DEVELOPMENT REVIEW BOARD
SUPPLEMENTAL SUBMITTAL

PROJECT NO. 2020-004757

RE: RV Storage – Albuquerque: DRB Resubmission

COMMENT RESPONSE LETTER

**RV STORAGE - ALBUQUERQUE
 ALBUQUERQUE, NEW MEXICO
 SITE PLAN
 UTILITY PLAN**

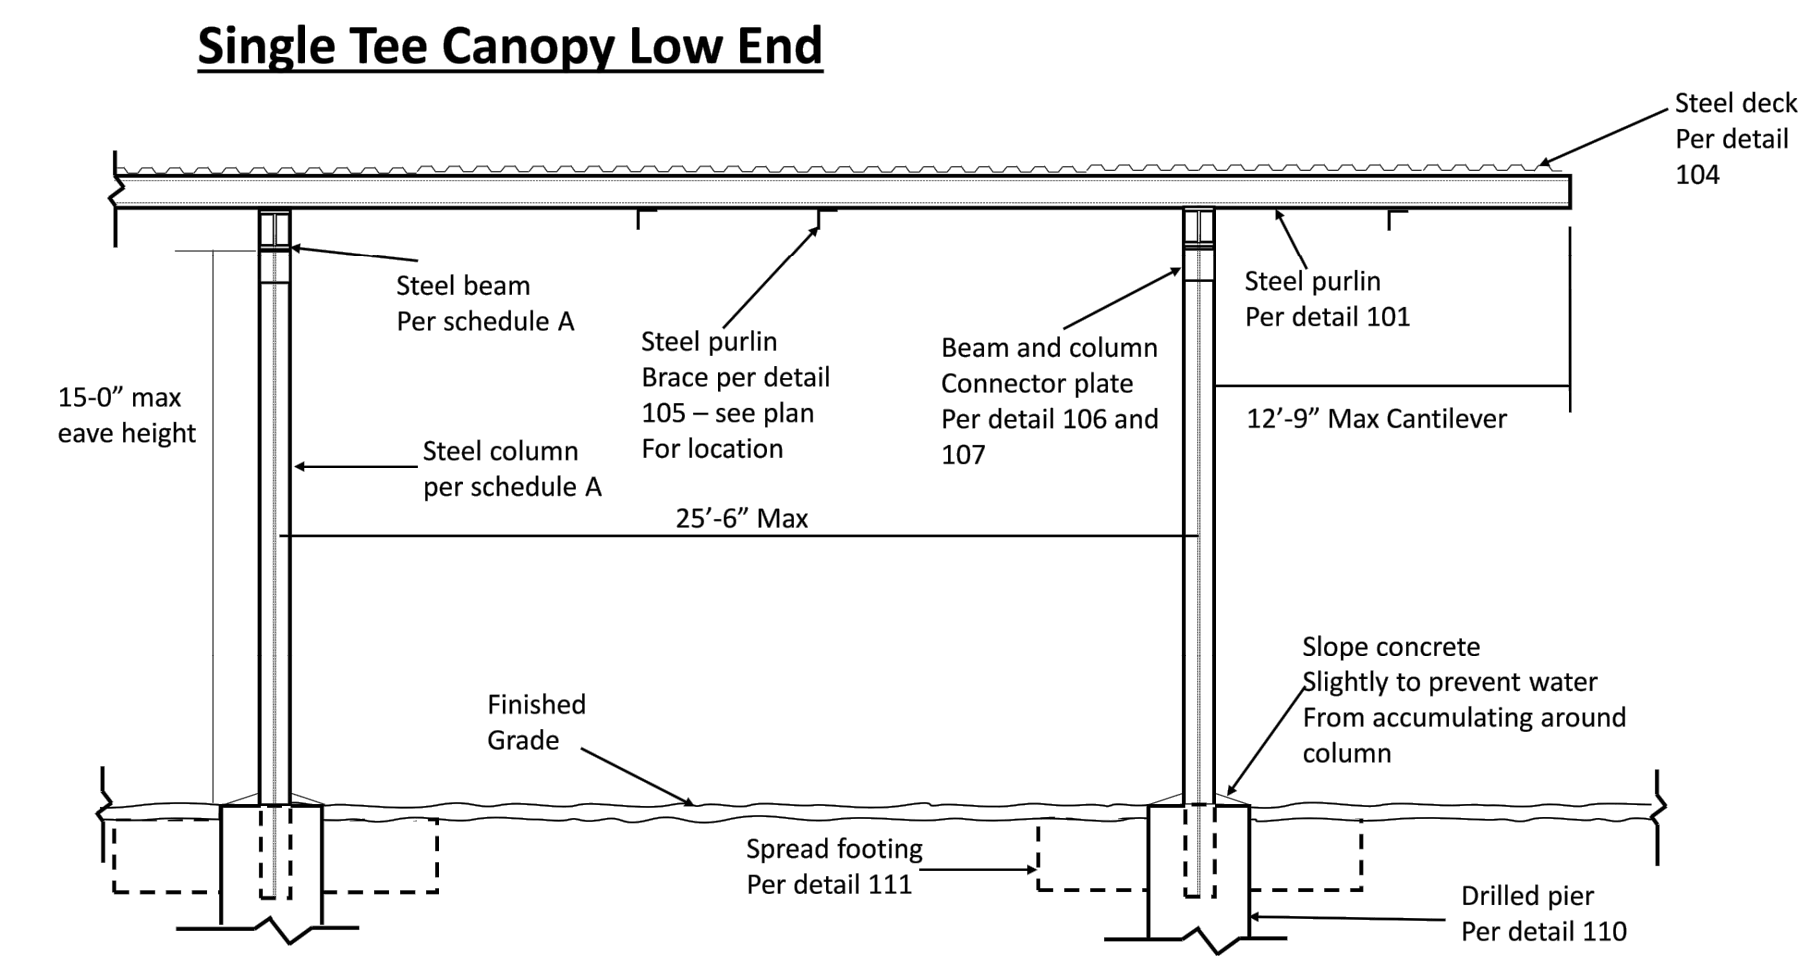
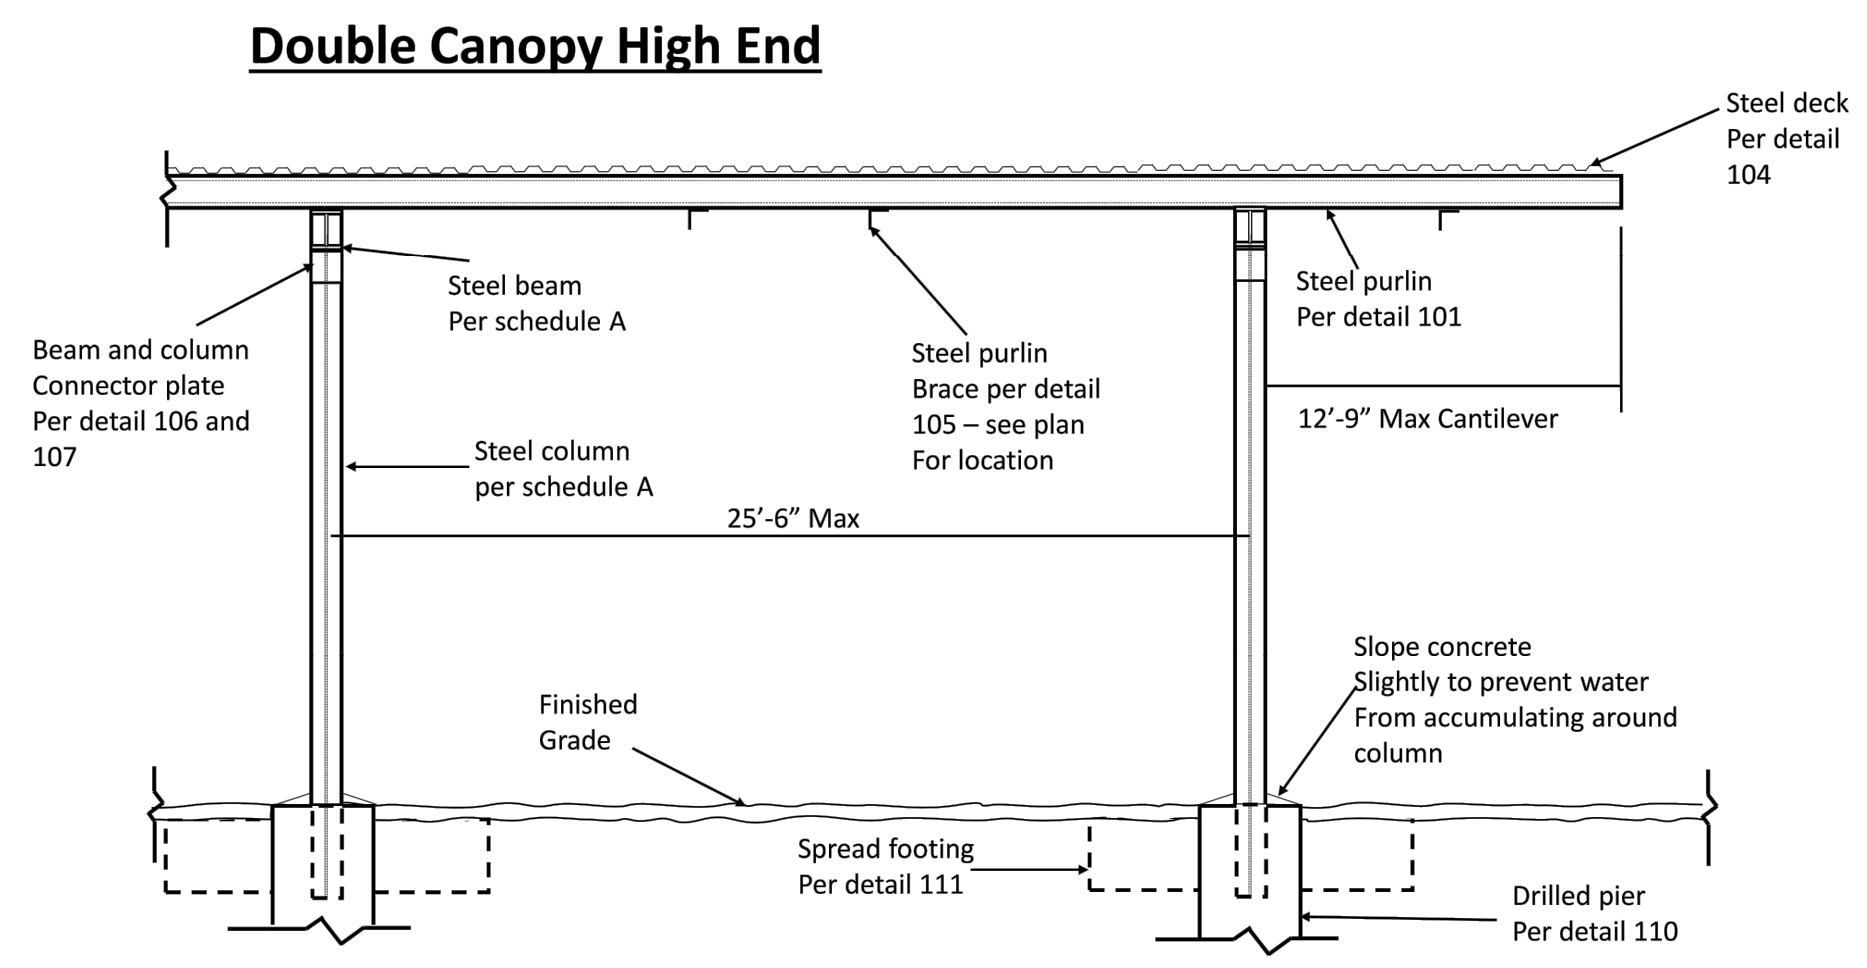
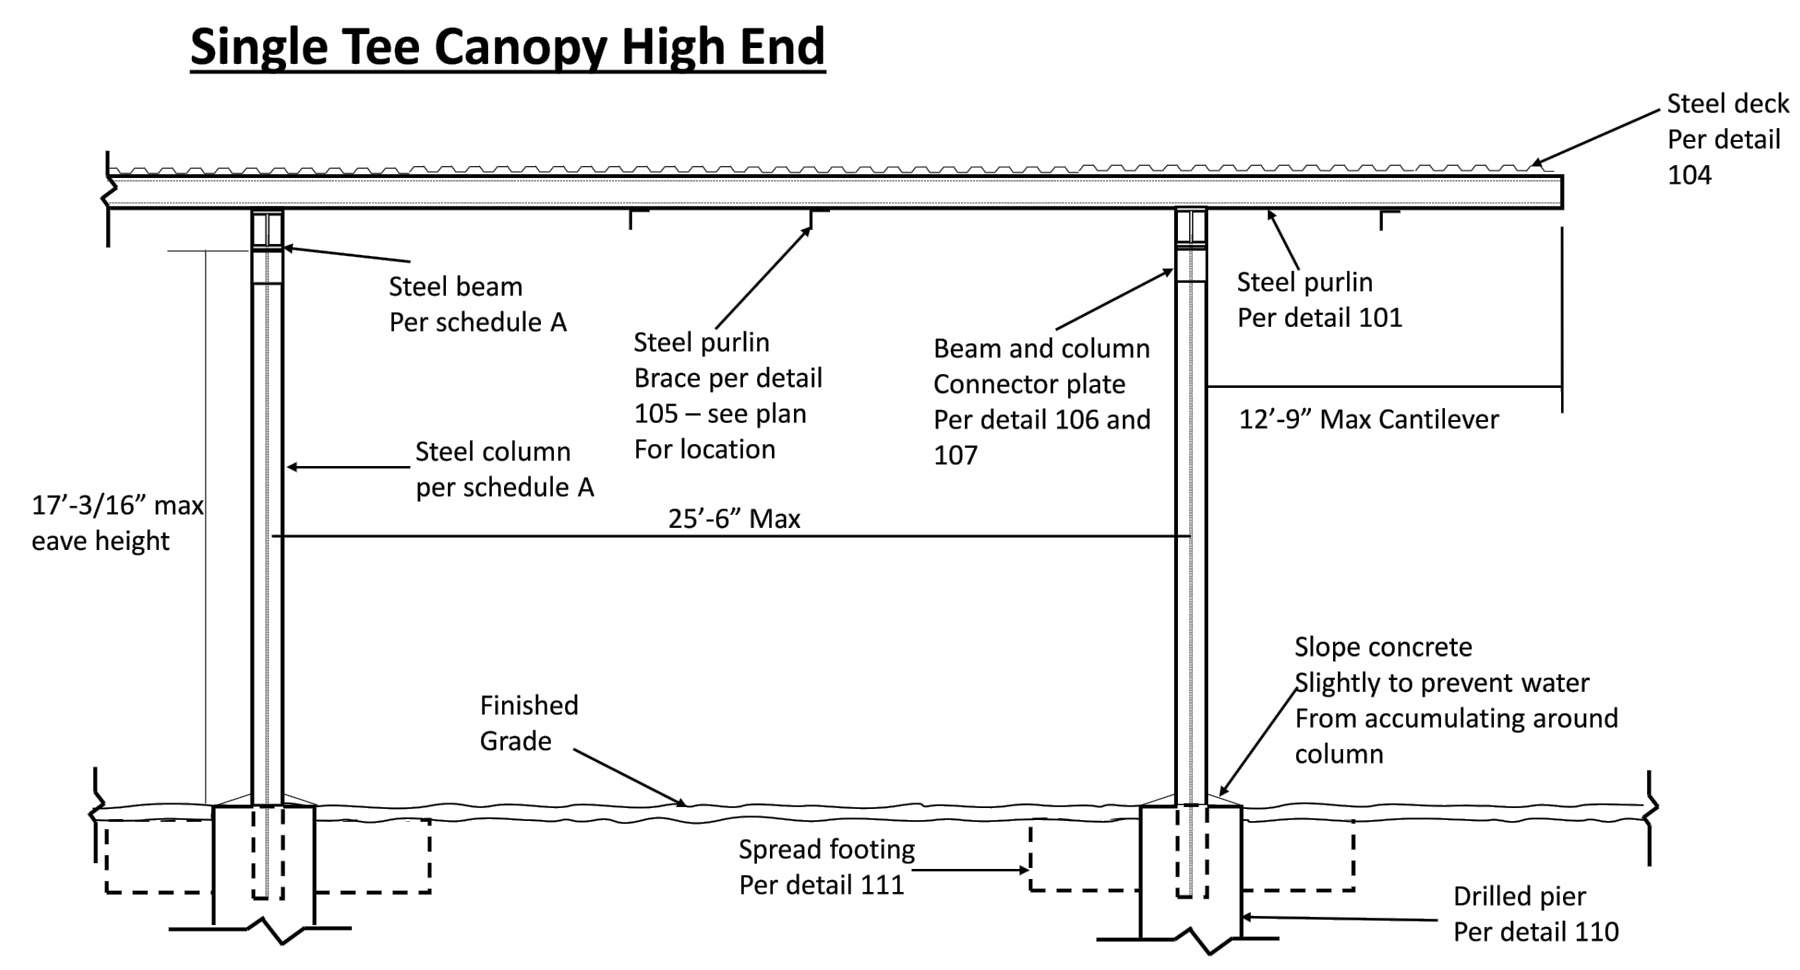
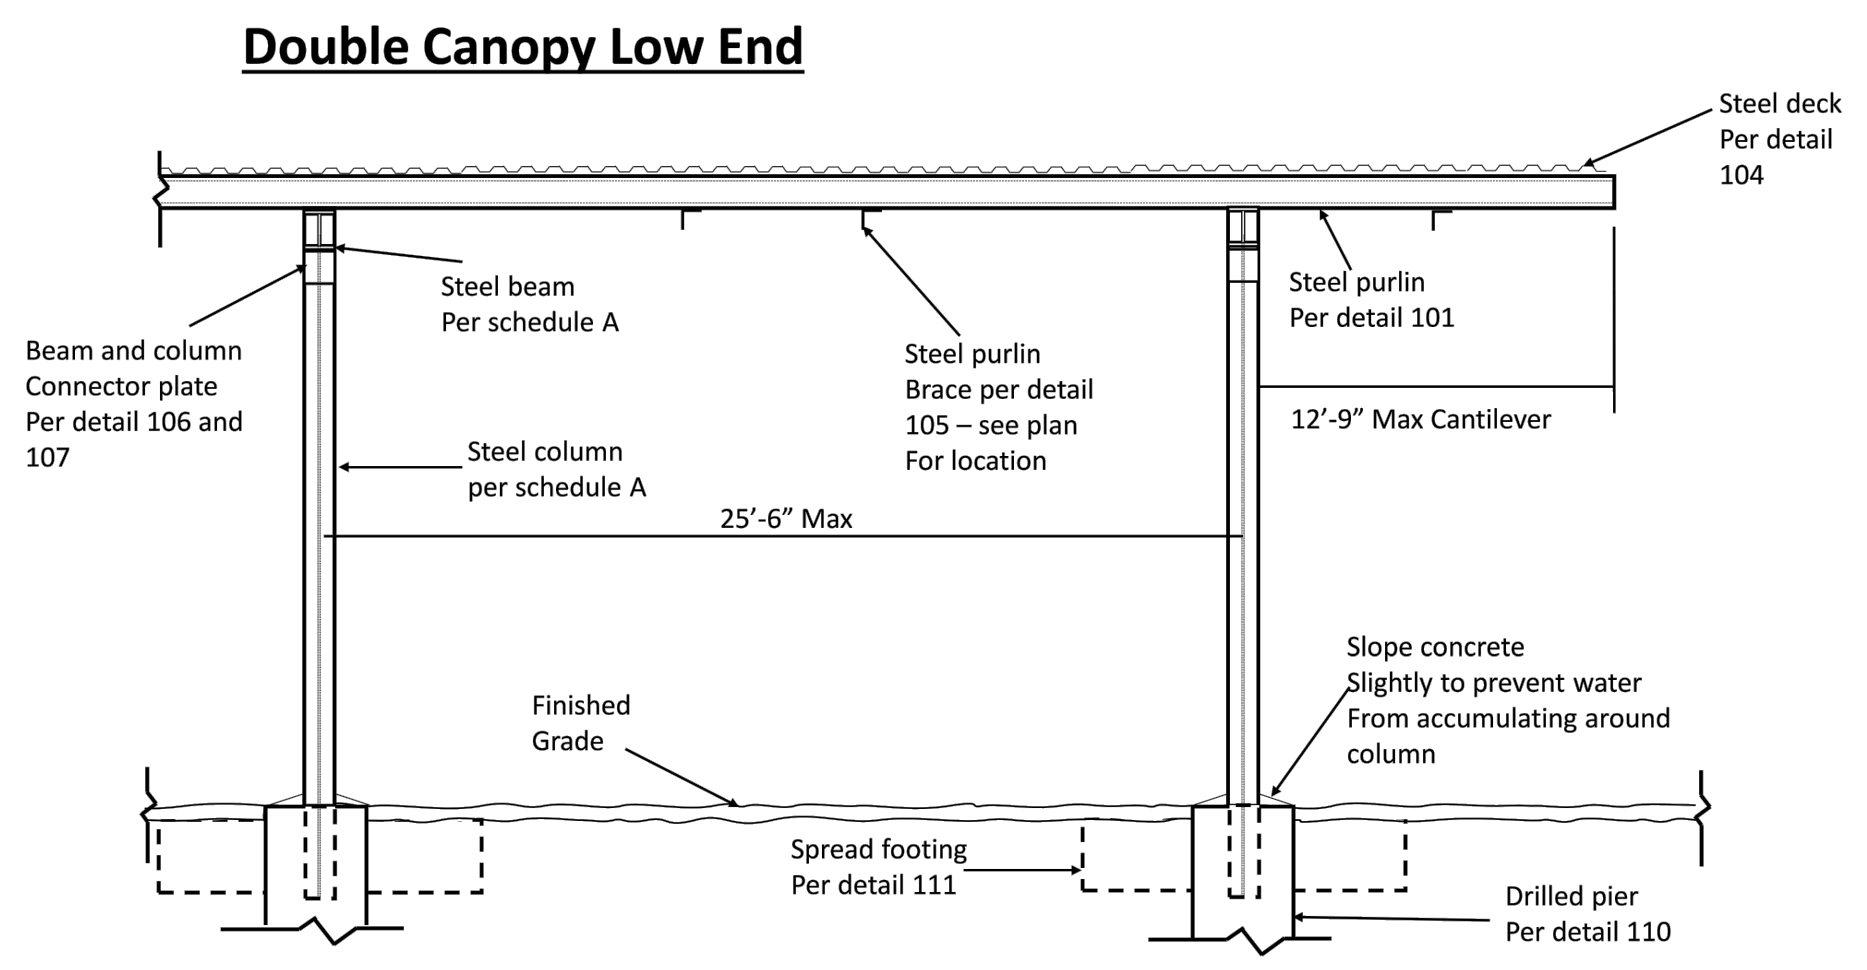
1. Availability Statement # 210111 has been issued and provides the conditions for service.
 - *Response: Acknowledged.*
2. Utility plan.
 - A. Revise Key Note A to refer to a public sanitary sewer main with typical slope to match DPM or as approved by ABCWUA.

- B. Revise Key Note E as needed, or add a new notes, so that there are not manholes located at every junction.
 - C. The connection of the site's service to the main shall be a routine service connection and not a manhole connection.

- D. The tie to the water main shall be on the east side and the upsize shall run the length of the property, as stated in the availability statement.

- E. Revise the meter location so it is not within the middle of the cul-de-sac.
 - F. The use of an RV Dump station typically generates sewage flows not accounted for by the water meter. A flat rate sewage account may be required by new services to account for this. Pretreatment may be required, please call Blaine Carter at 505-415-9188 so that we may coordinate with the pre-treatment section. Provisions to protect the sanitary sewer collection point from stormwater will be required.

- *Response:*
 - *A. The keynote has been revised as requested.*
 - *B. The manhole locations have been revised and a new keynote has been added.*
 - *C. Acknowledged. The site service connection to the main has been revised to be a routine service connection.*

- *D. Acknowledged. The water layout has been revised.*
 - *E. The location of the water meter has been revised.*
 - *F. Acknowledged. This will be discussed with Blaine Carter at the provided phone number.*
